# CITY OF ALBUQUERQUE

September 20, 2012

**Re: Boulders Phase I and II  
Grading and Drainage Plan  
Engineer's Stamp Date 8/28/2012 (B11/D001C)**

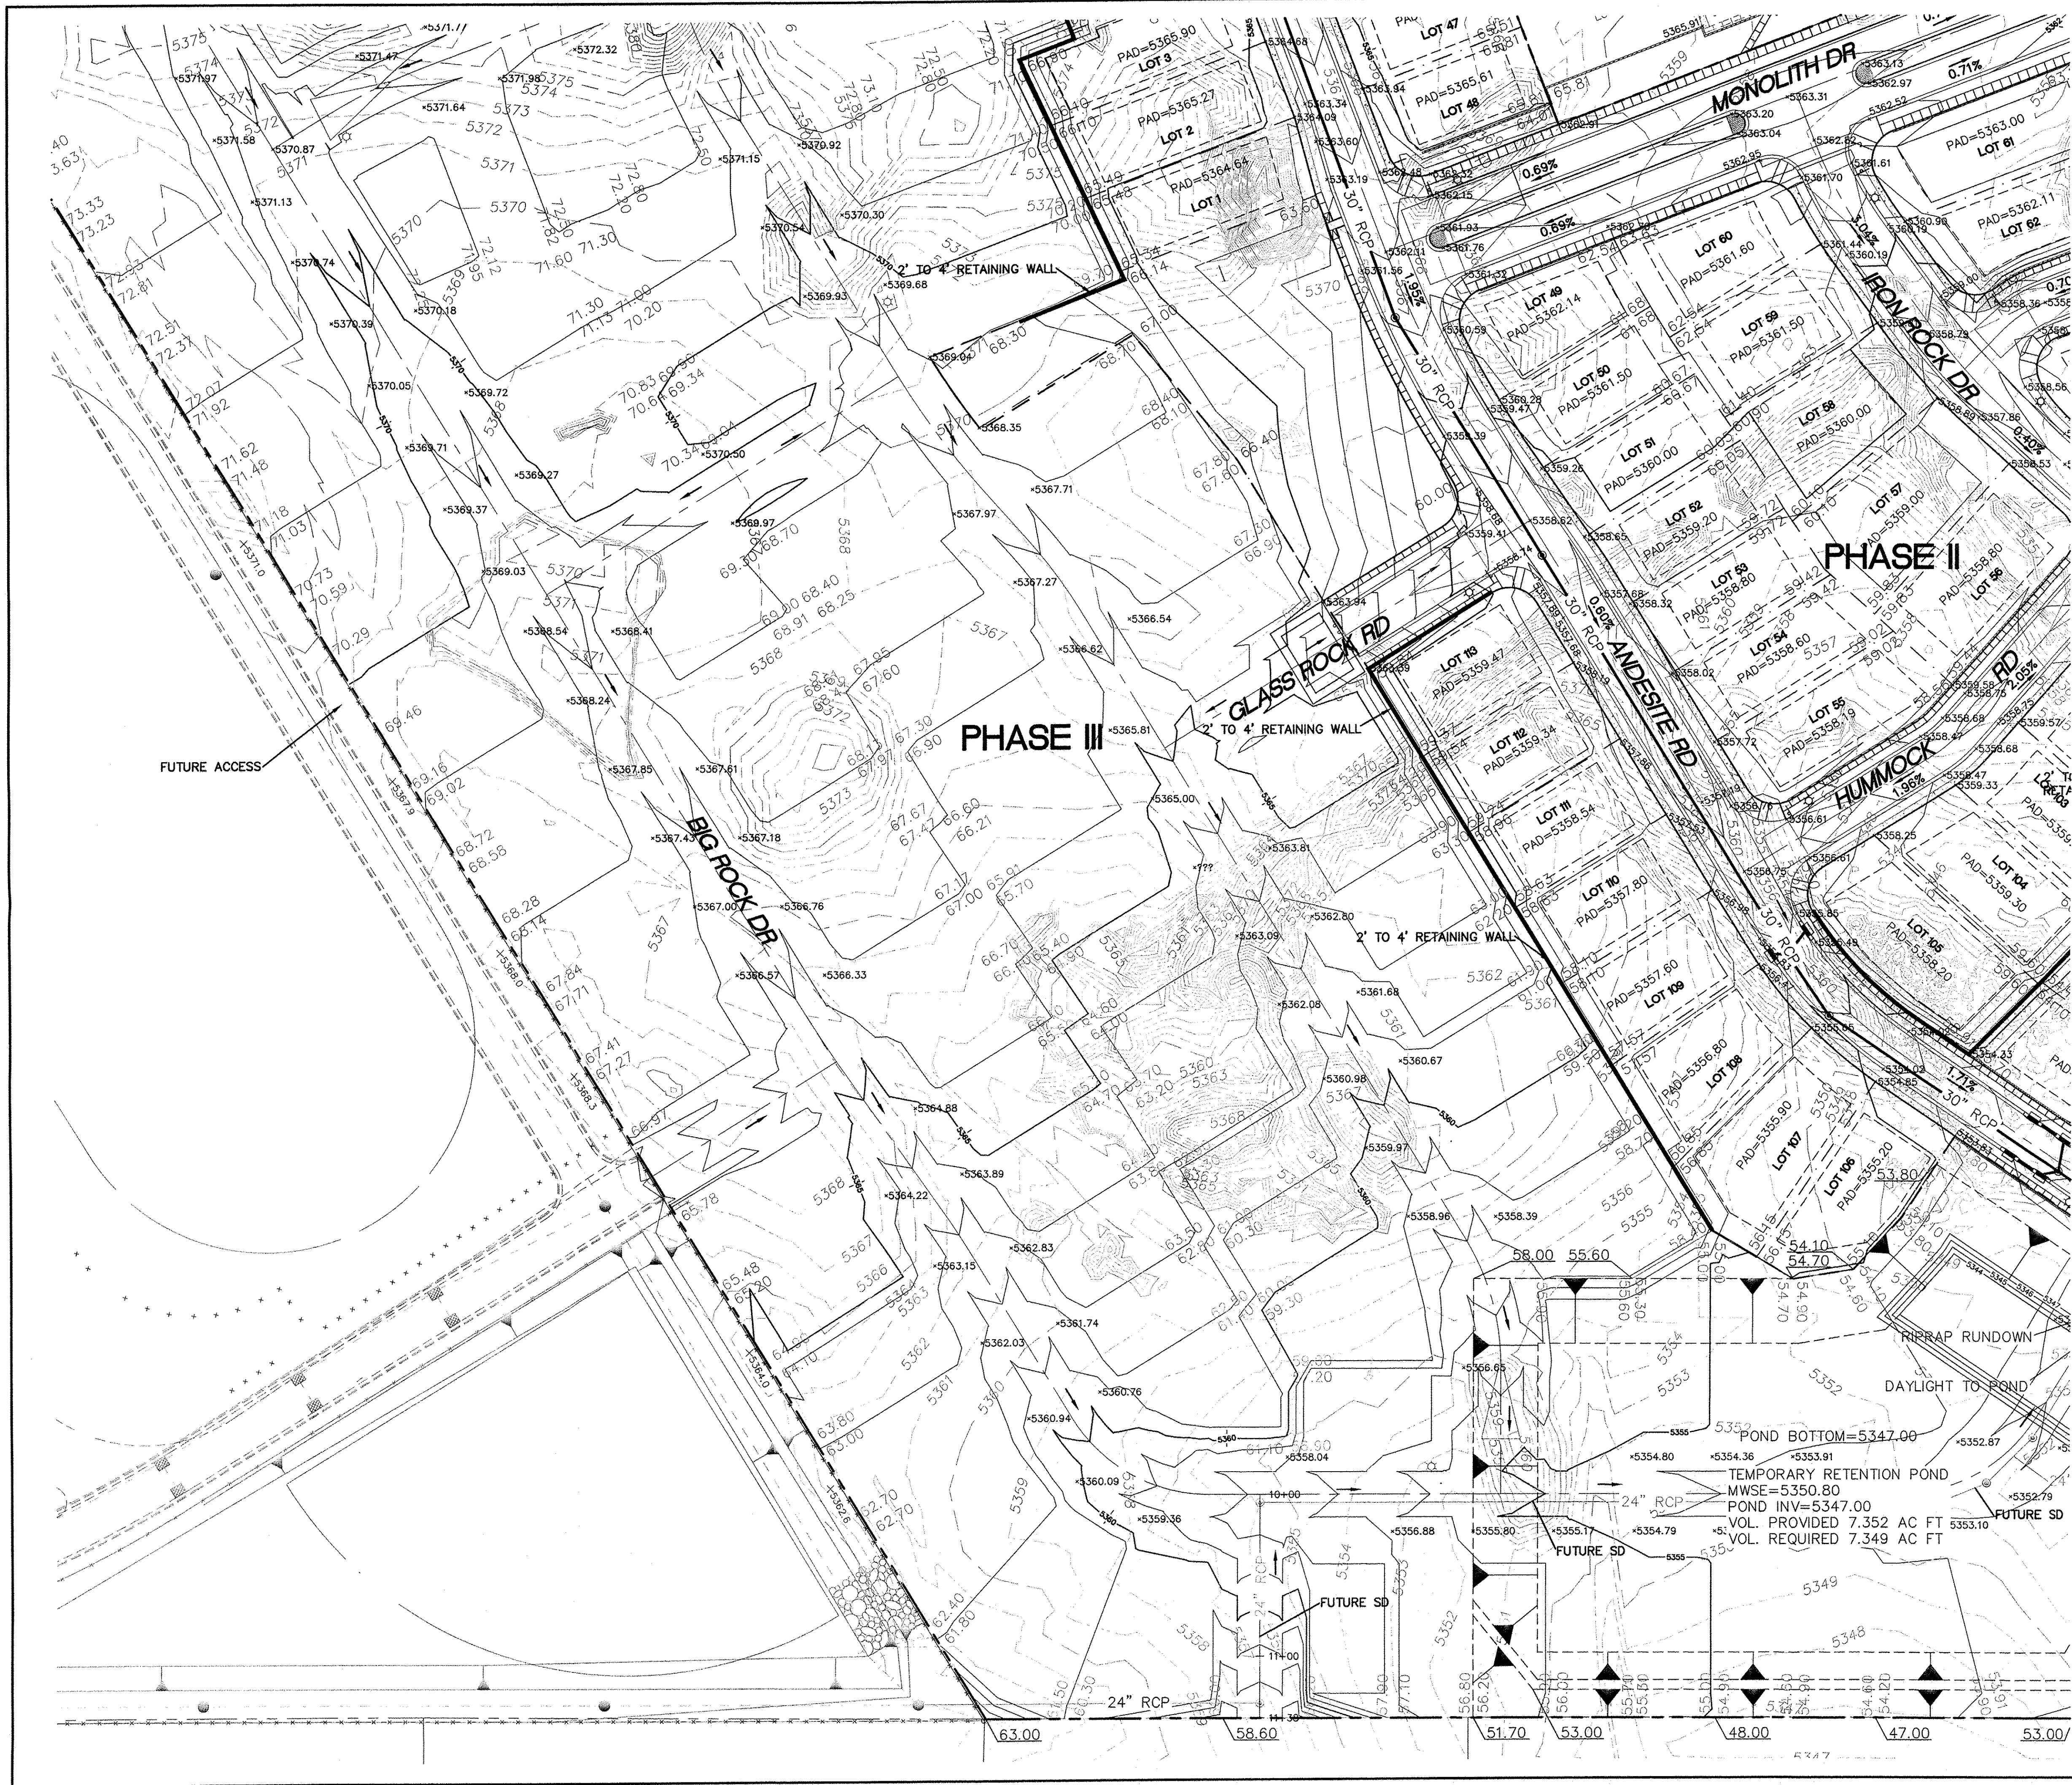
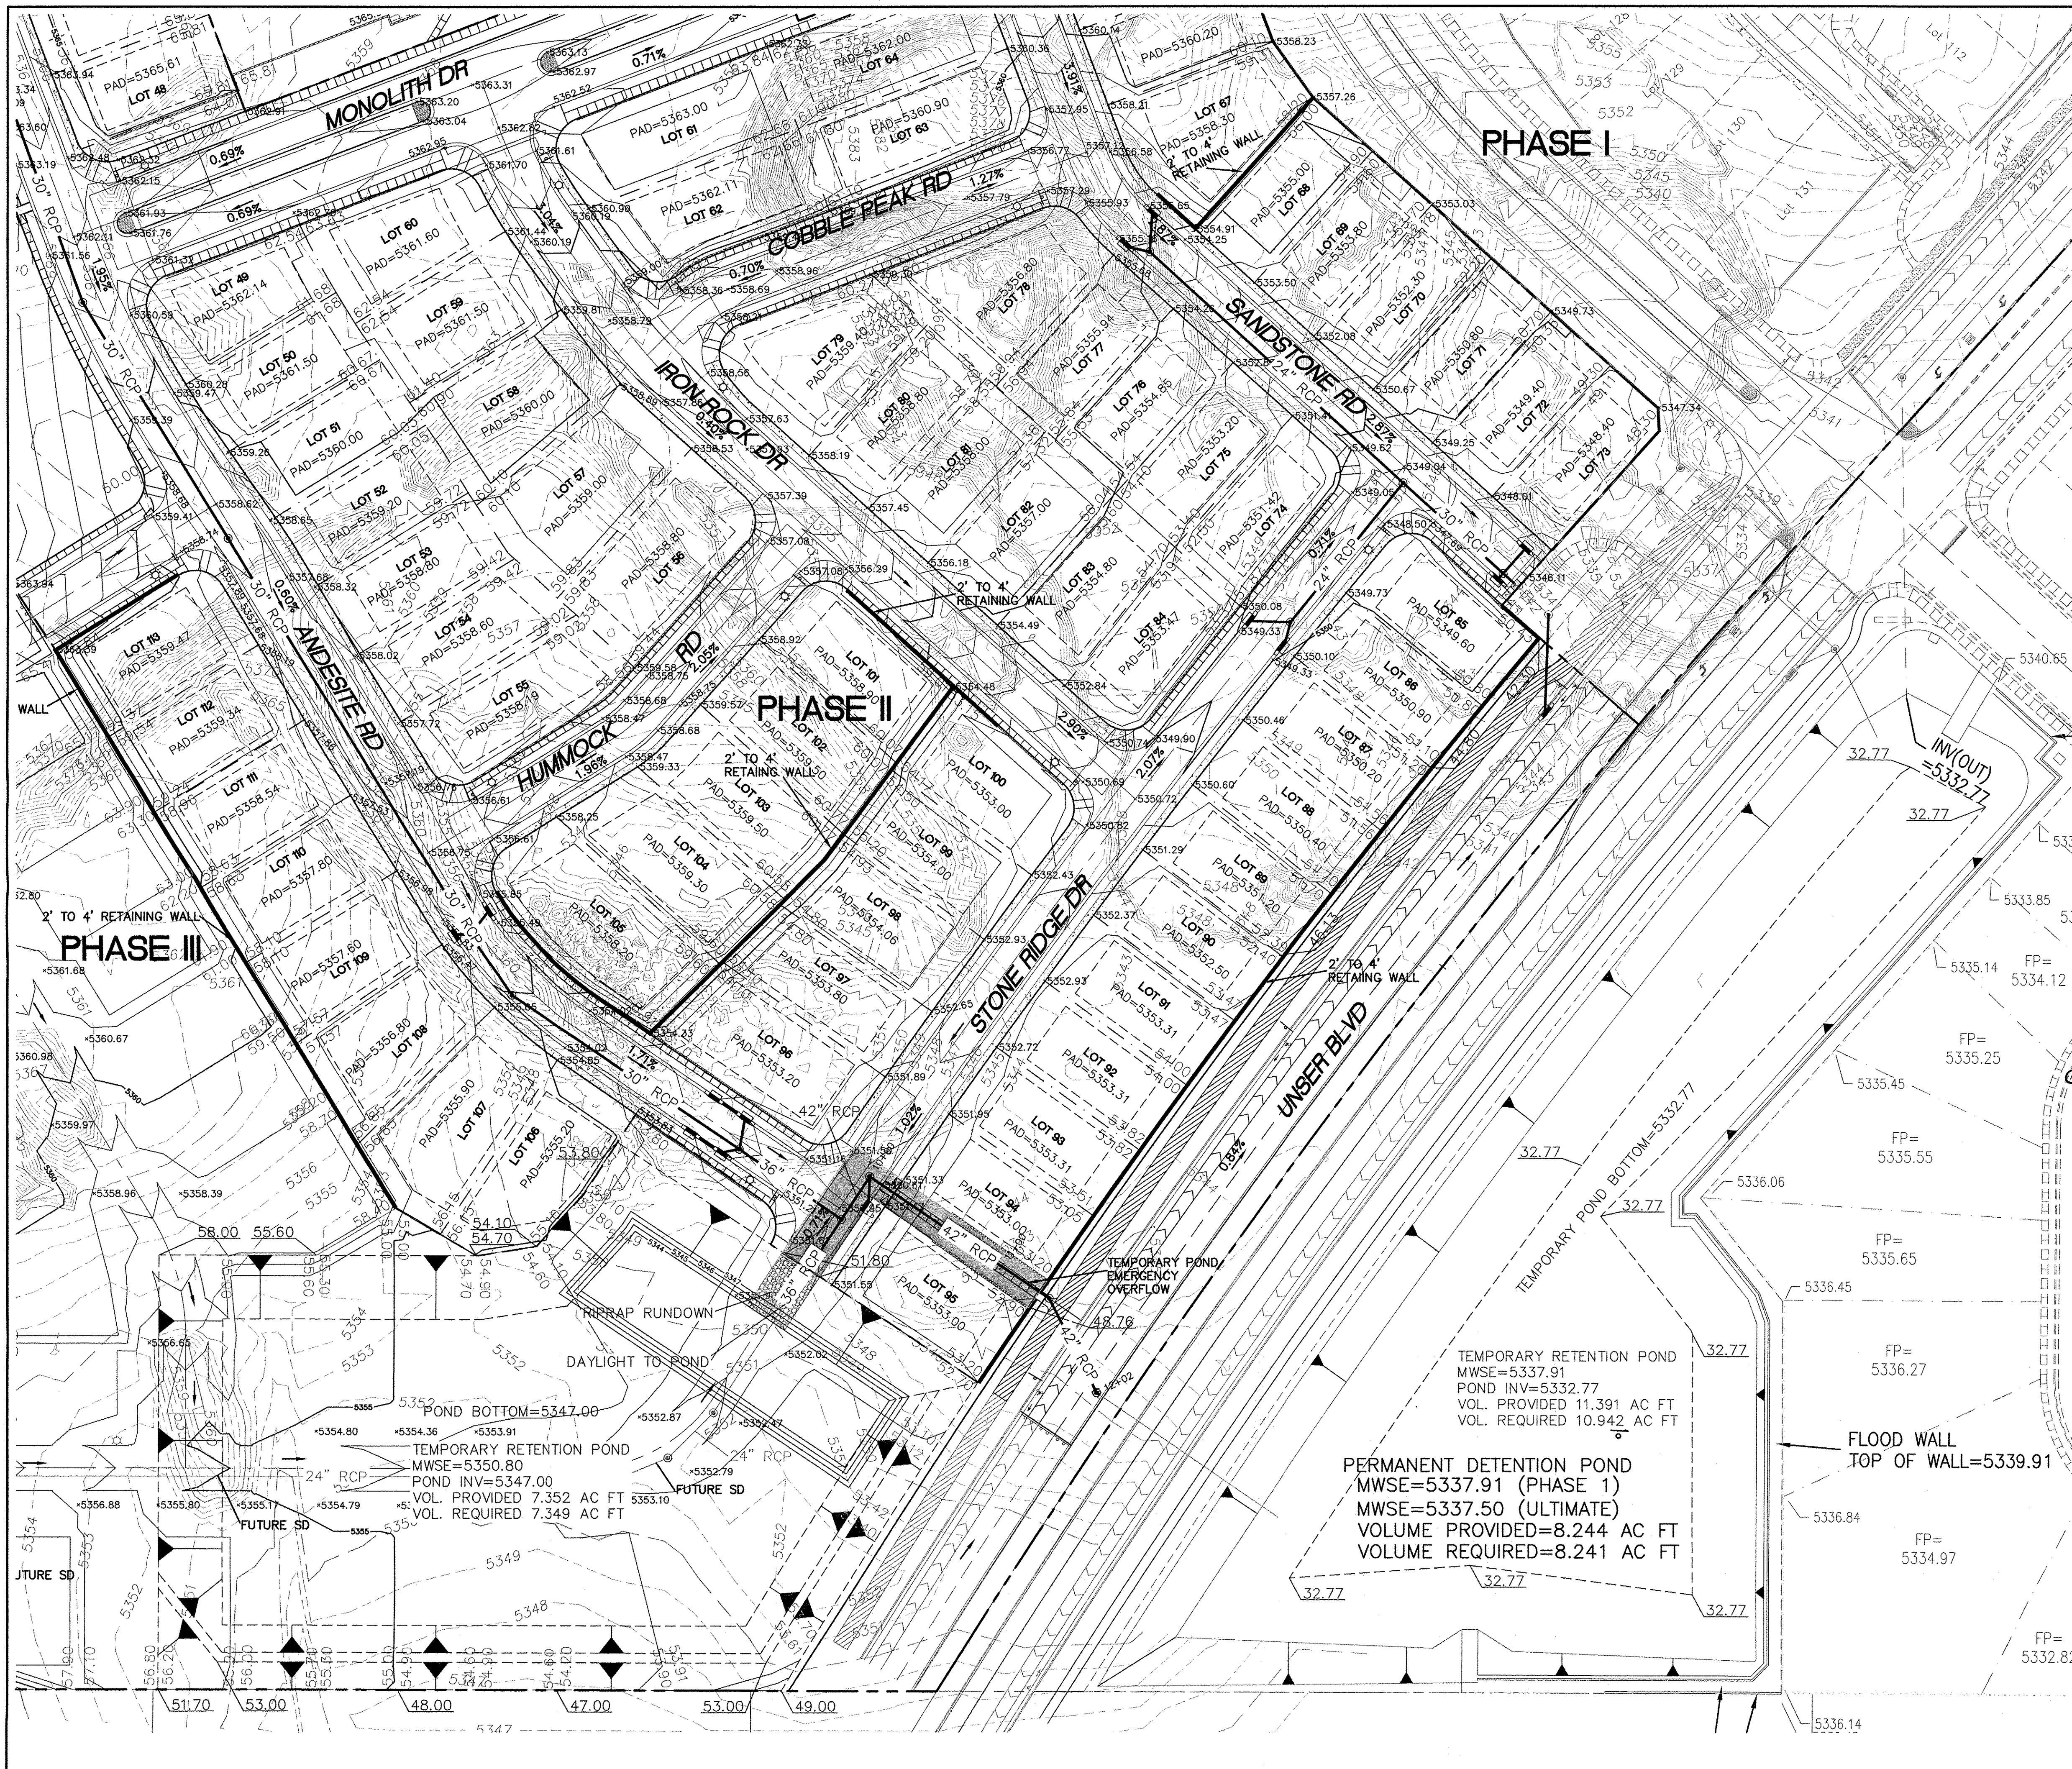
- Provide additional wall elevation for the walls west of Lots 107 through 113 and South of Lots 101 through 105.
- Please make sure walls West of Lot 21 and NW corner of Lot 101 does not encroach into the clear site triangle.
- Remove the sidewalk culvert note between lots 29 and 30.
- Desilting pond may be required at the west end of Jagged Peak Road and Glass Rock Road.
- Riprap may be required at the south end of Big Rock Drive.
- Provide emergency overflow calculations for the pond east of Unser Boulevard.
